SWS-SUSXW-S185-001763

Diversion of Sewers – Section 185, Water Industry Act 1991

Location: University of Chichester EDT Park, Bognor Regis Campus, Upper Bognor Road, Bognor Regis, West Sussex, PO21 1HR.

| TITLE:   | SOUTHERN WATER<br>S185 DEVELOPER DIVERSION APPLICATION PLAN<br>LONG-SECTION<br>PIPE BED & SURROUND DETAILS |

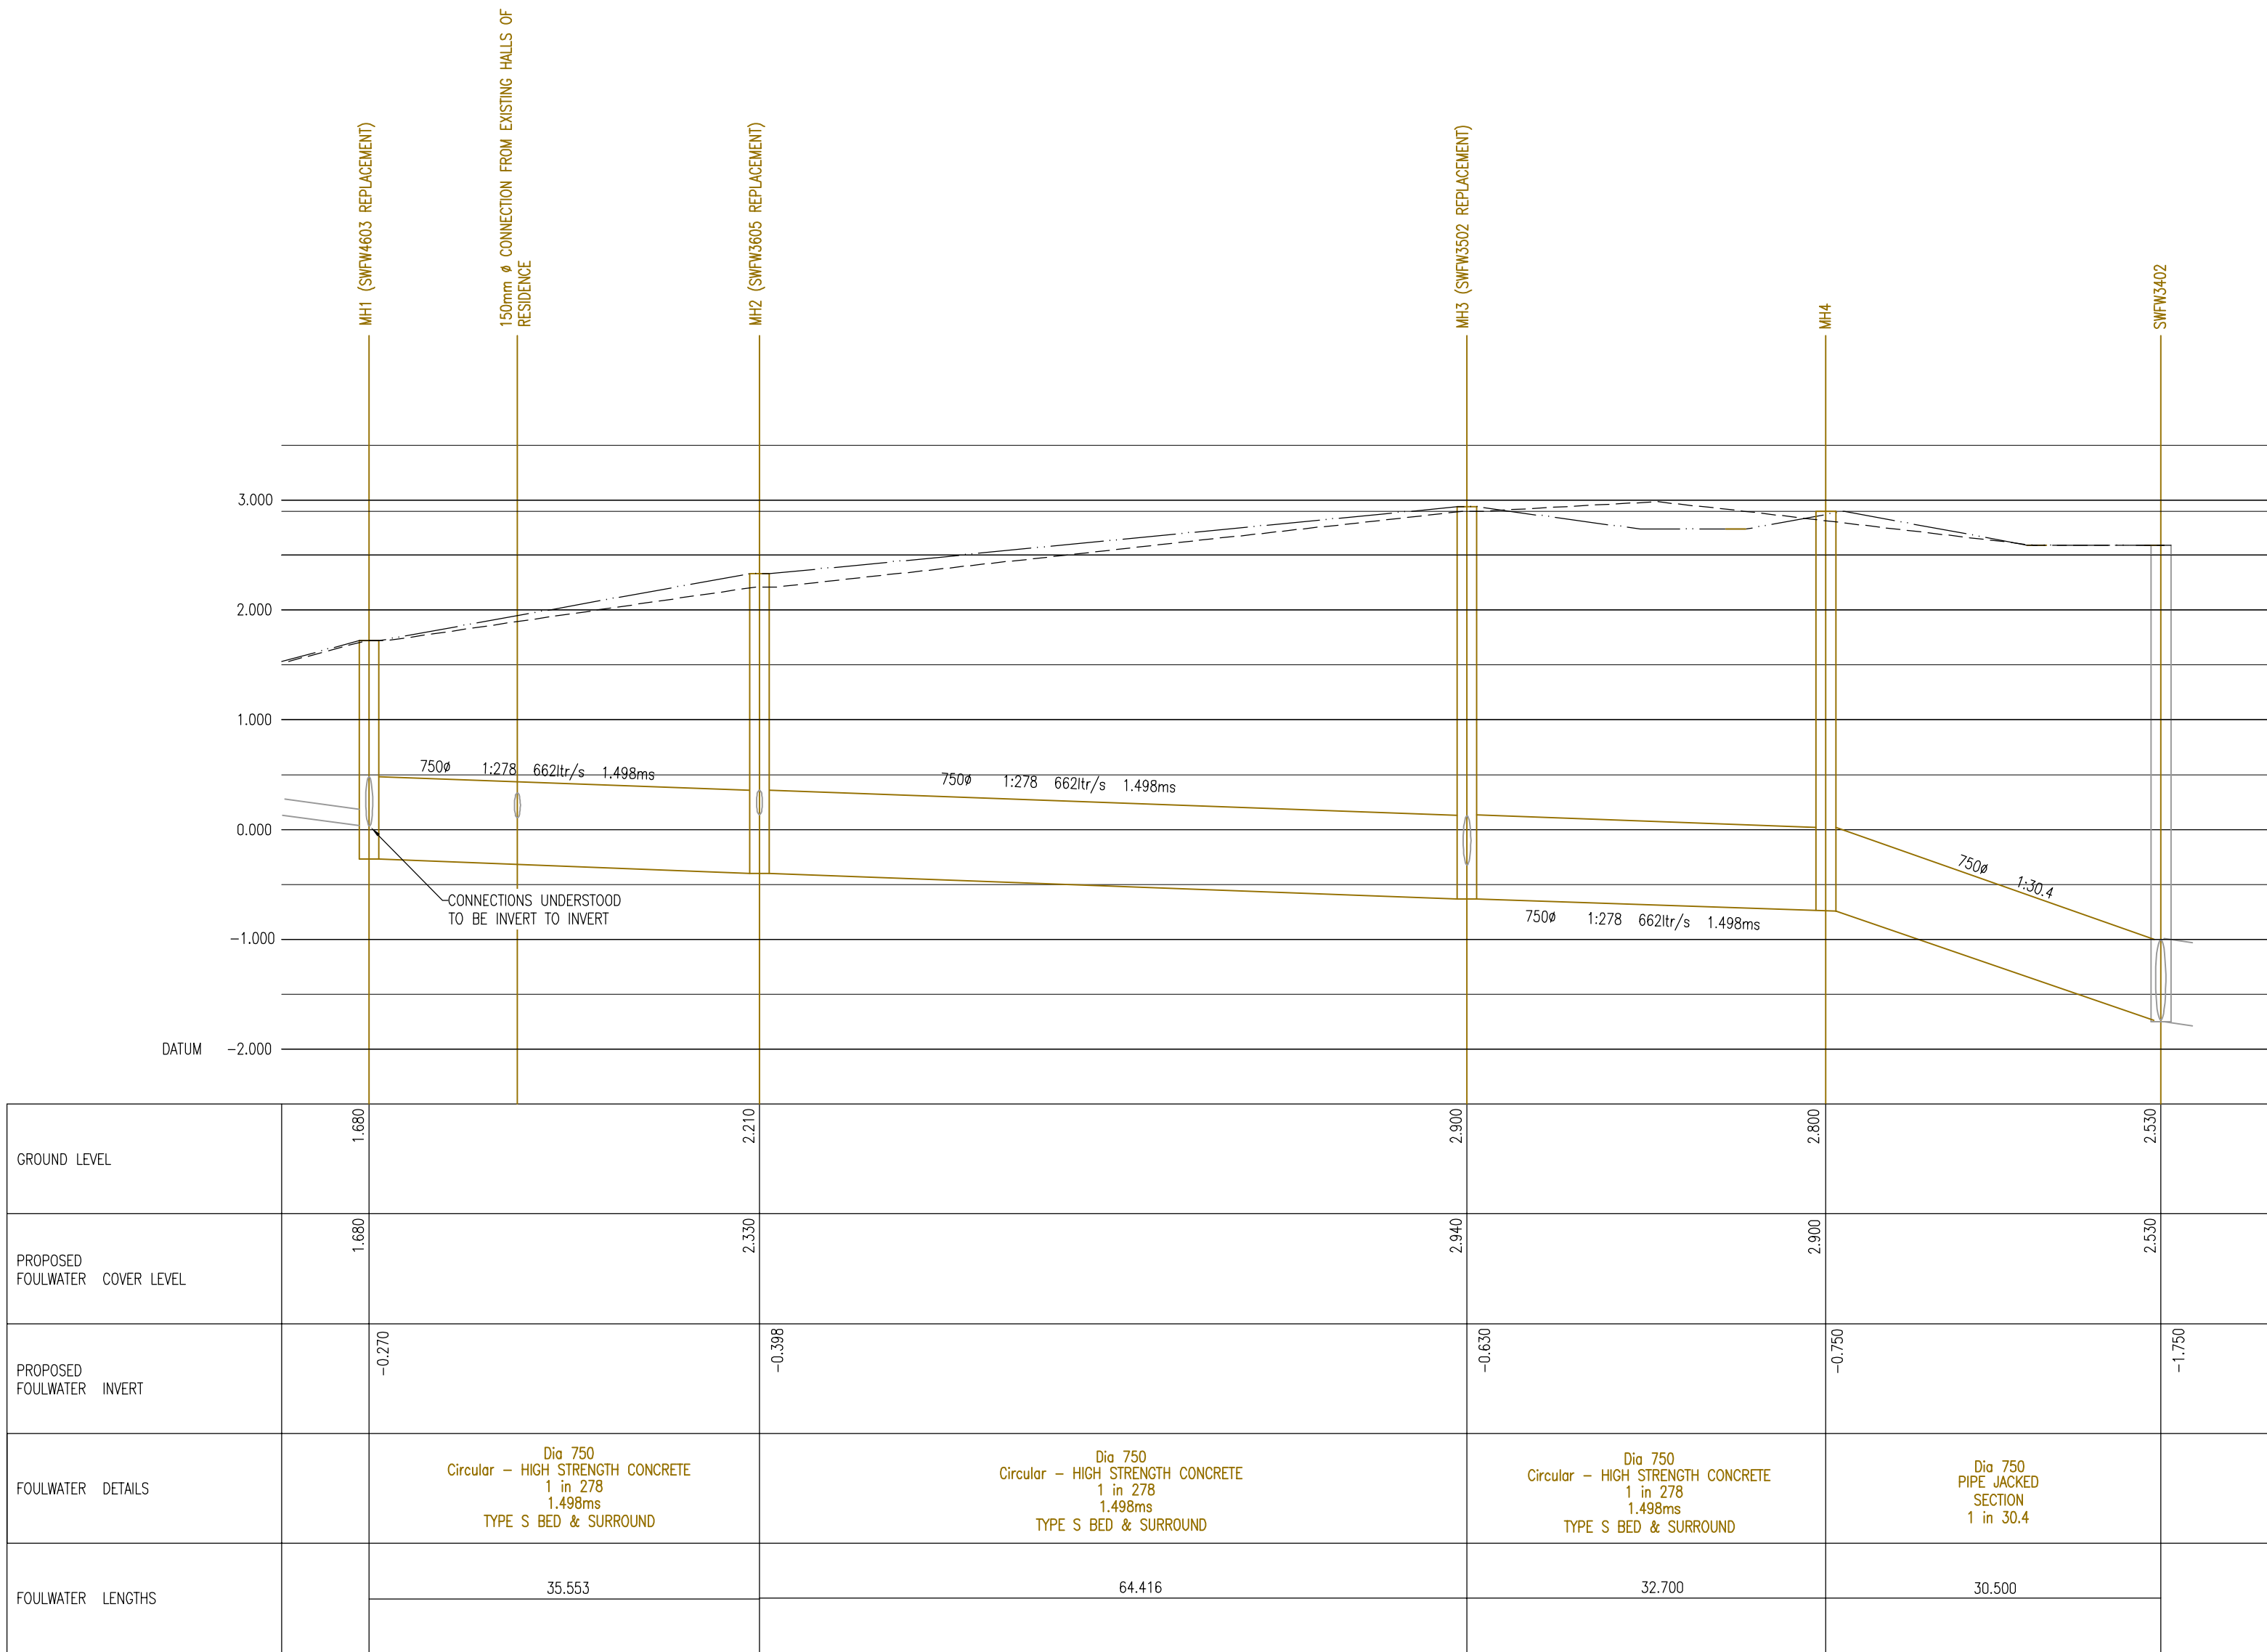
I refer to the proposed public sewer diversion at the above site and I thank you for your email received 2nd November 2016. I am pleased to confirm that your proposals shown on drawing number 0938/D/101 Rev F Southern Water S185 Developer Diversion Applications Plan Drainage Network are acceptable on the condition that we receive an acceptable long section, a temporary works package and the location of the rising mains are confirmed.
